DOC18/545361  
SSD-7173 – MOD 3

**Altis Warehouse and Logistics Hub - 585-649 Mamre Road, Orchard Hills (SSD-7173 – MOD 3)  
– Notice of Modification**

### **Altis Warehouse and Logistics Hub - 585-649 Mamre Road, Orchard Hills (SSD-7173 – MOD 3) – Notice of Modification**

Figure 4: Field validated vegetation communities (Ecoplanning 2015) and proposed watercourse realignment.

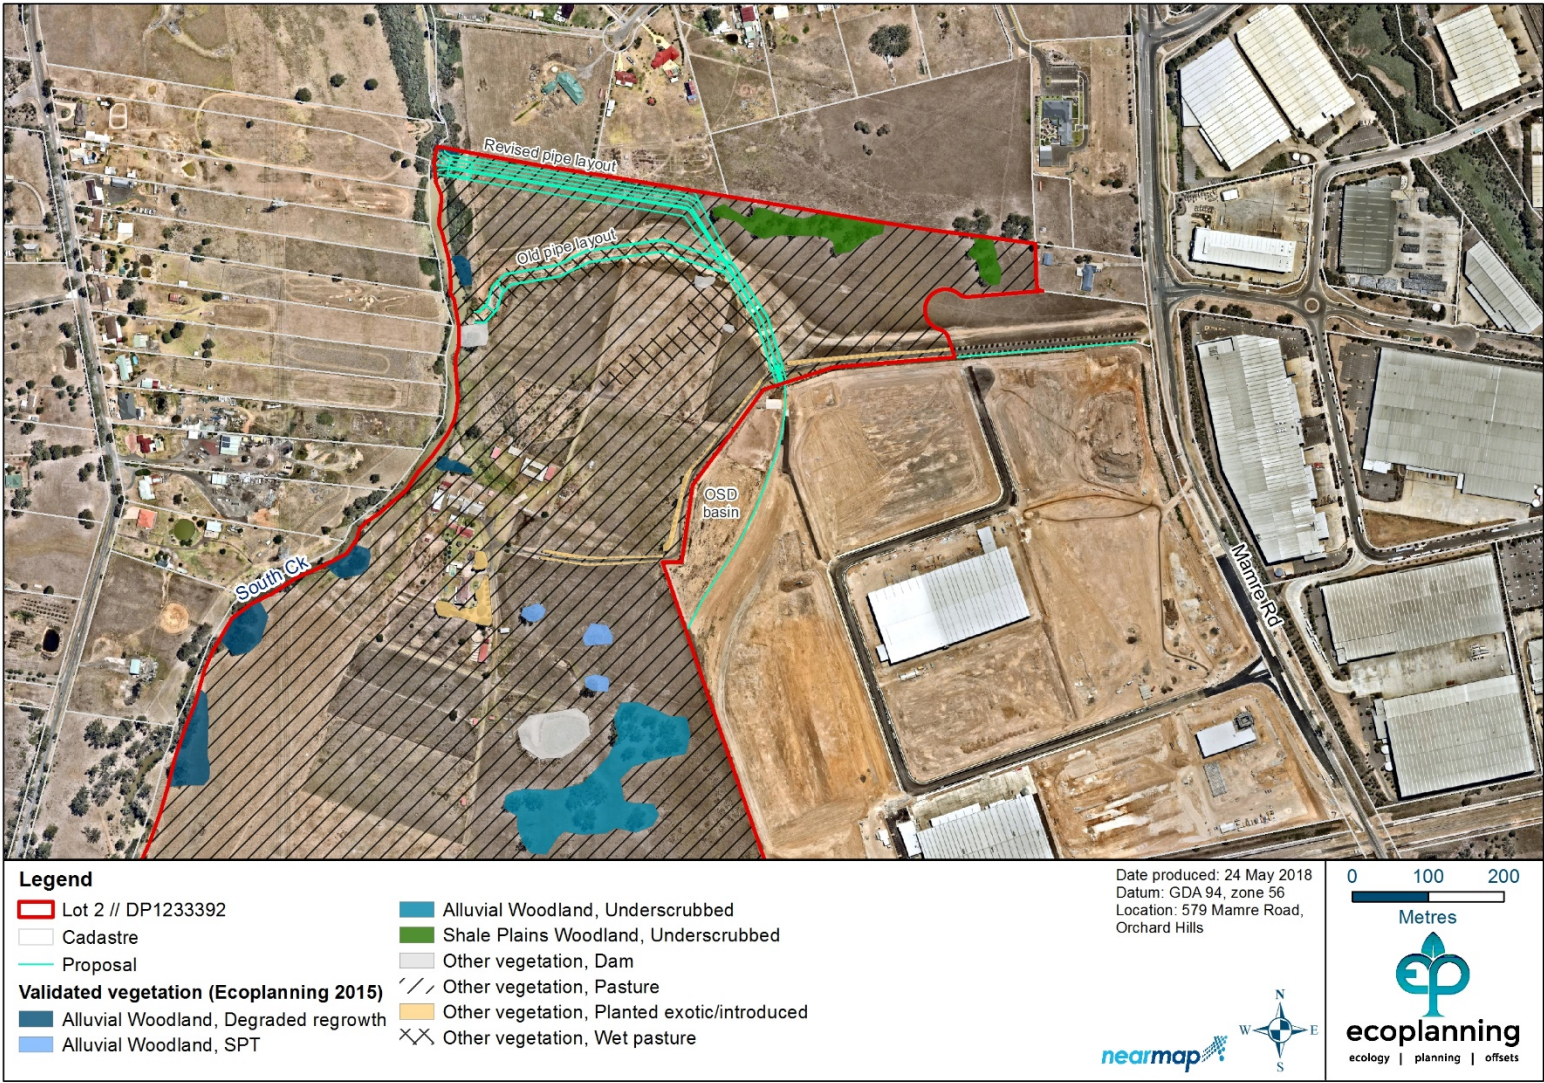
There is potential for the construction and excavation of the new channel to impact Aboriginal archaeology, particularly as:

- there is an existing Aboriginal site (45-5-4717) recorded in 2016 in close proximity to the existing channel and the proposed works. The modification proposal could impact on these sites
- there is an existing Aboriginal site (45-5-4719) recorded in 2016 on the SSD-7173 site
- the channel maximum width is to be 23 m and drainage easement for the new channel is to be 35m wide (see Section 2, page 3 of Modification report)
- the channel works are located on RU2 (Rural Landscape) zoned land and may have had minimal past ground disturbance
- the works are in close proximity to South Creek which has cultural landscape value to Aboriginal people.

Figure 5 | Approved and Proposed Drainage Works

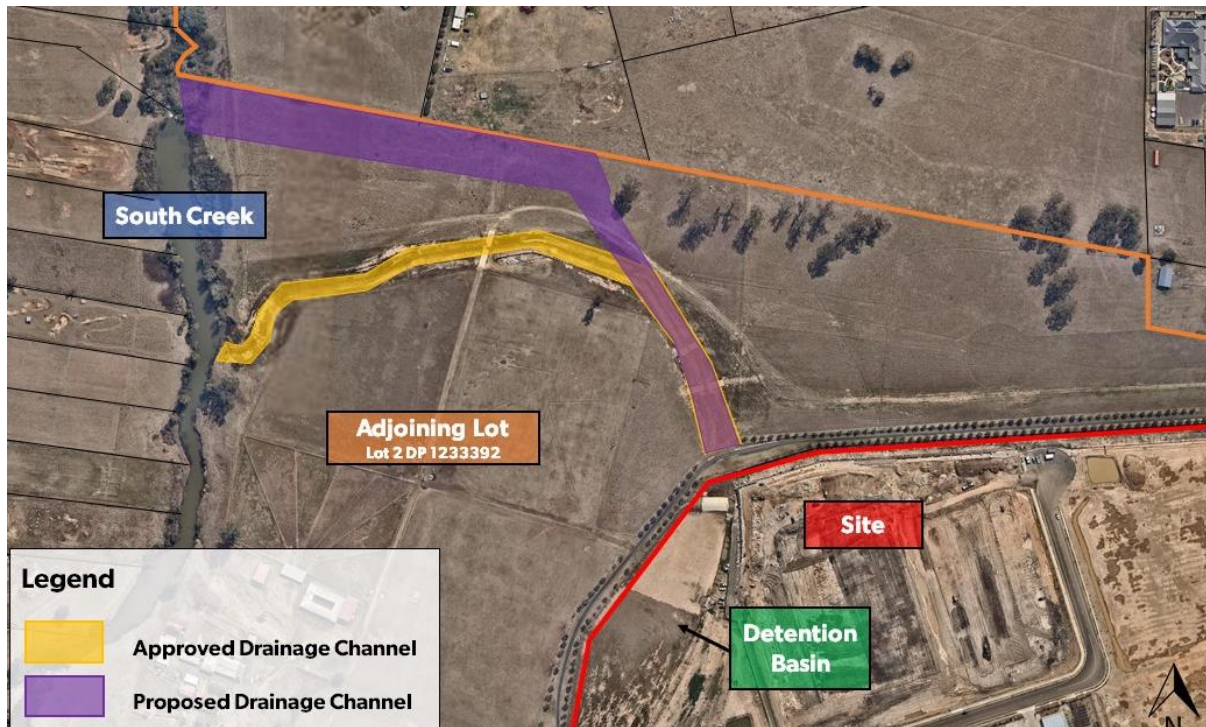
The Modification report indicates the MOD 3 application proposes to construct a new drainage channel to replace the current realigned channel. In relation to the new channel, it is recommended:

- a fully vegetated riparian corridor is established along either side of the new channel (measured from top of bank) consisting of a diversity of local provenance native plant species from the relevant native vegetation community
- local native grass species and native shrubs are established along the channel batters to assist stabilise the channel and improve habitat value
- the outlet of the new channel and bank of South Creek near the proposed works is revegetated with local native vegetation to improve habitat, stabilise the bank and mitigate the potential for scouring

In relation to the proposed filling of the existing channel to pre-existing levels, it is recommended:

- the riparian corridor along South Creek where the existing channel is proposed to be filled is revegetated with a diversity of local provenance native plant species from the relevant native vegetation community.
